CITY OF ALBUQUERQUE

**Re: Lot 21-A Block 2 Unit 19 Volcano Cliffs, S.A.D. 228
7704 Compass Dr. NW
Request Permanent C.O. – Accepted
Engineer's Stamp Dated: 12-10-2019 (D10D003G21A)
Pad Certification dated: 1/14/2020
CO Certification dated: No Date
Revised Certification dated: 9/15/2020**

**Re: Lot 21-A Block 2 Unit 19 Volcano Cliffs, S.A.D. 228
7704 Compass Dr. NW
Request for Permanent C.O. – Not Accepted
Engineer's Stamp Dated: 12-10-2020 (D10D003G21A)
Pad Certification dated: 1/14/2019
CO Certification dated: No Date**

Based on the Certification received 9/11/2020, this site cannot be accepted for release of Certificate of Occupancy by Hydrology until the following comments are addressed.

RAMOS, MANUEL (M. SANCHEZ) - GRADING & DRAINAGE PLAN

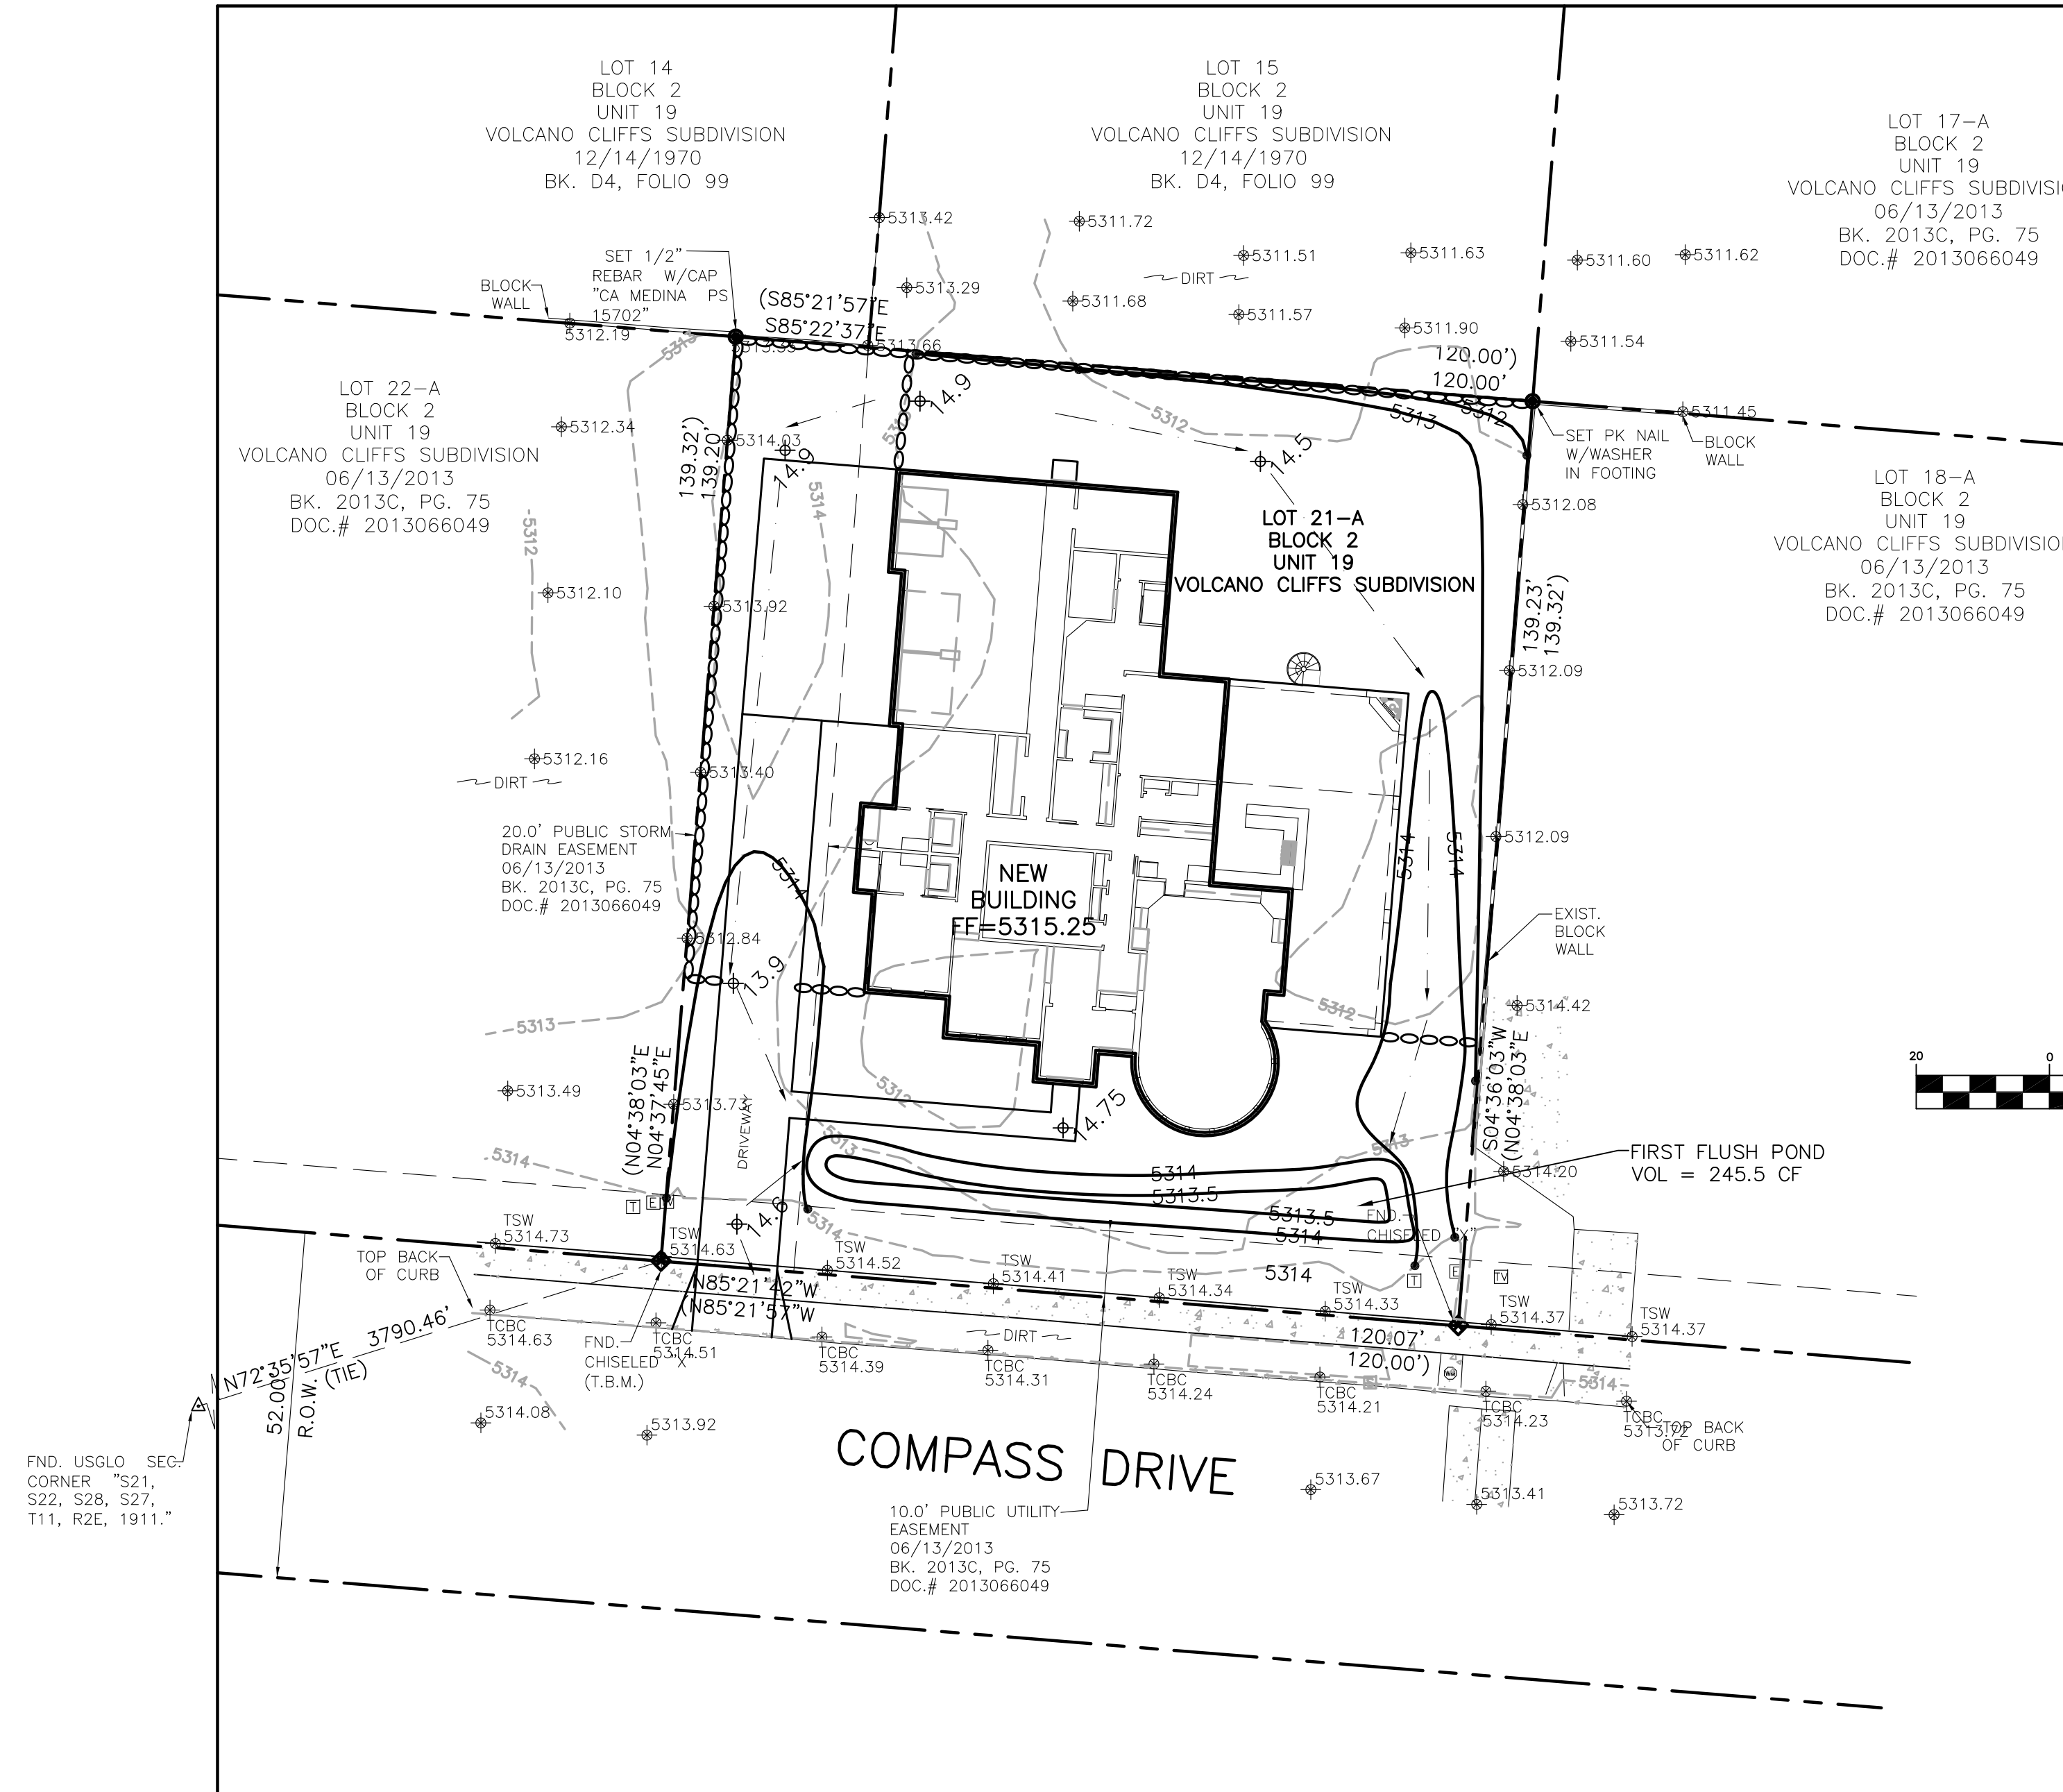
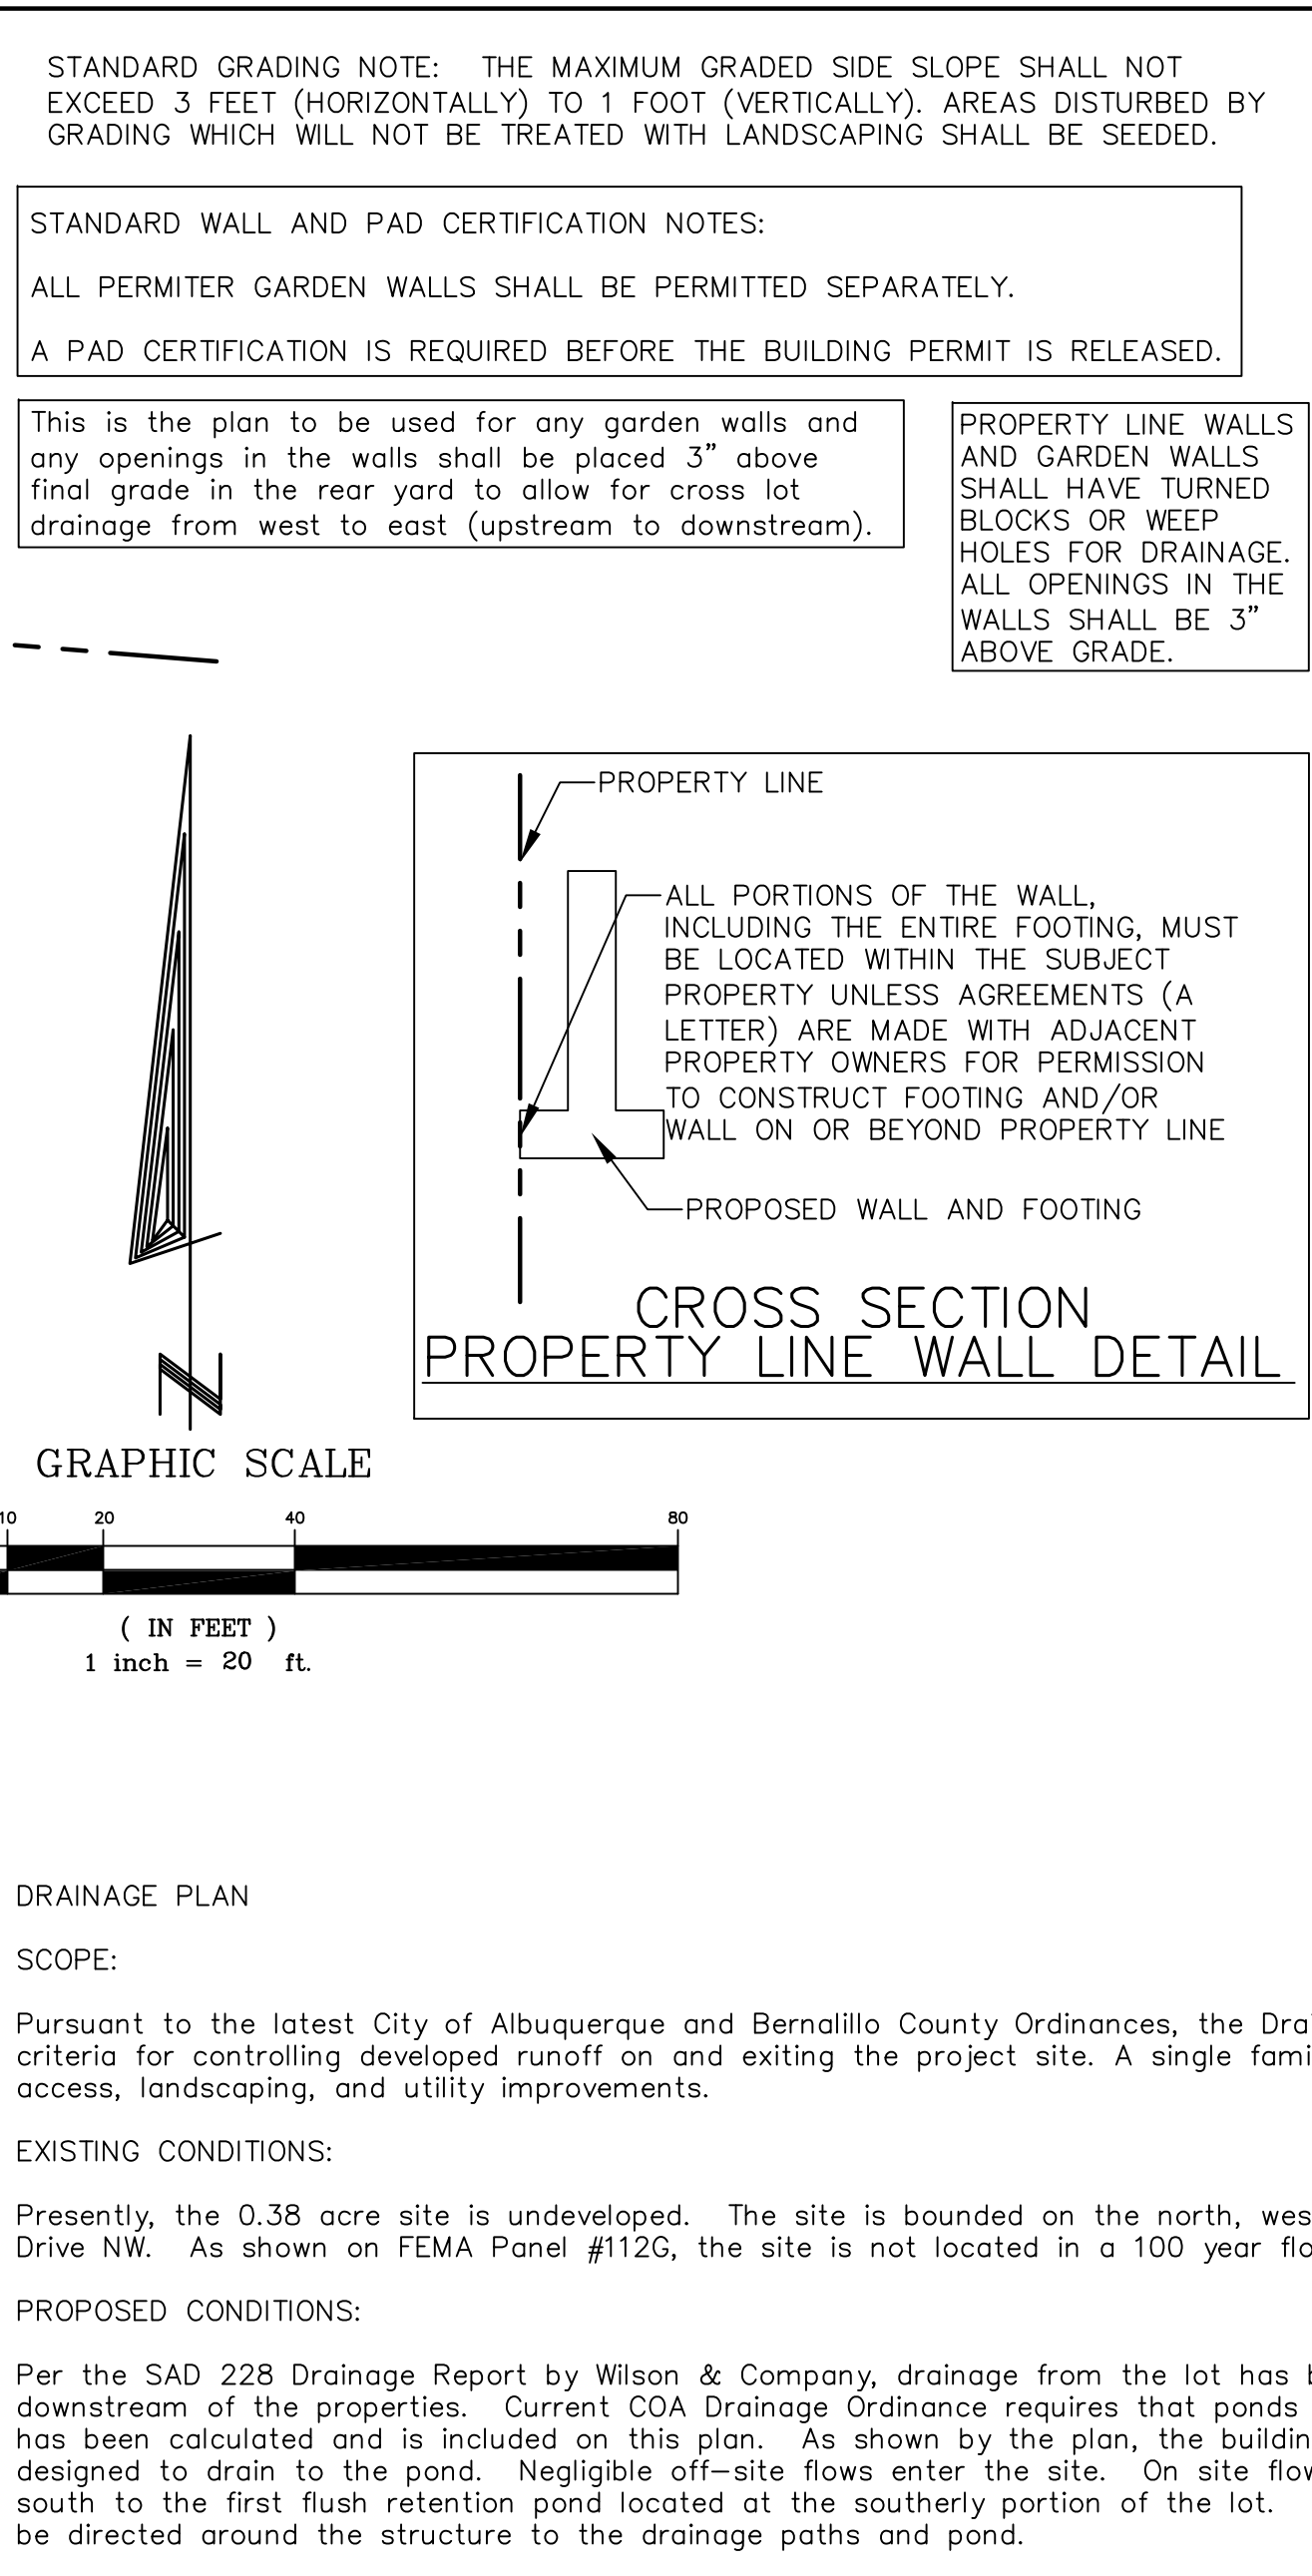
- Provide a signature and date for the CO. **added**
- Provide landscaping for ponds and swales. **added**
- Provide the drive pad. **added note that the driveway material will be gravel - per discussions with the owner and you**
